SUBJECT: SFD2402-0046
SINGLE FAMILY DWELLING

Here are the results of all Inspections located at **691 KRAMER RD:**

FRONT ELEVATION
SCALE: 1/4" = 1'0"

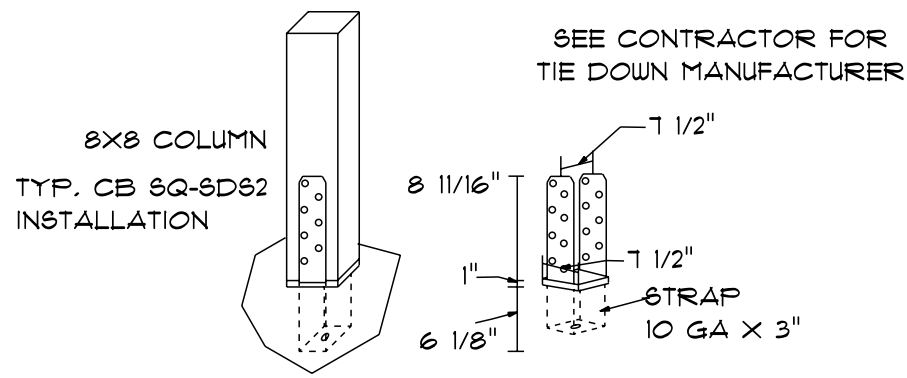
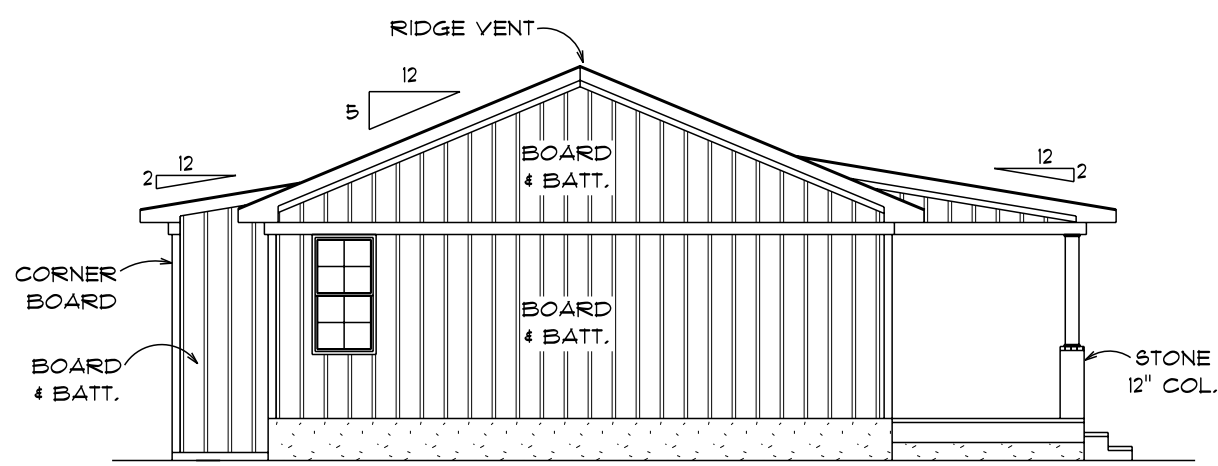
Missing flashing on front porch
Porch post not installed at time of inspection
Missing insulation baffles
Replace warped ceiling joist in kitchen
Missing support on headers at attic access hole
Need 3' head of water on drain line test
Missing nail guard on water line at bathroom sink
Need 2 king studs each side of window in front bedroom
Drain lines under house need support every 4' per code
Need 100 psi on water line test has 60 psi

REAR ELEVATION
SCALE: 1/8" = 1'0"

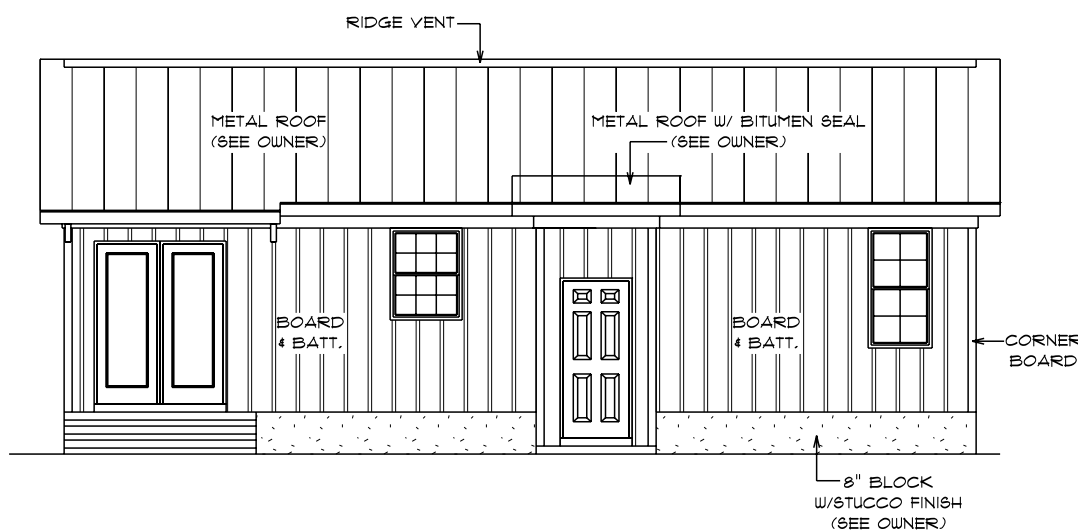
Inspection Type: ROUGH IN REINSPECT
Scheduled Date/Time: 12/2/2024
Completed Date/Time: 12/2/2024
Inspector: John B Kokoszka
Result: DISAPPROVED
Remarks:
Notes: Need complete set of plans Missing rear sliding door. Needs to be dried in. No test on the Plumbing. Didn't do inspection
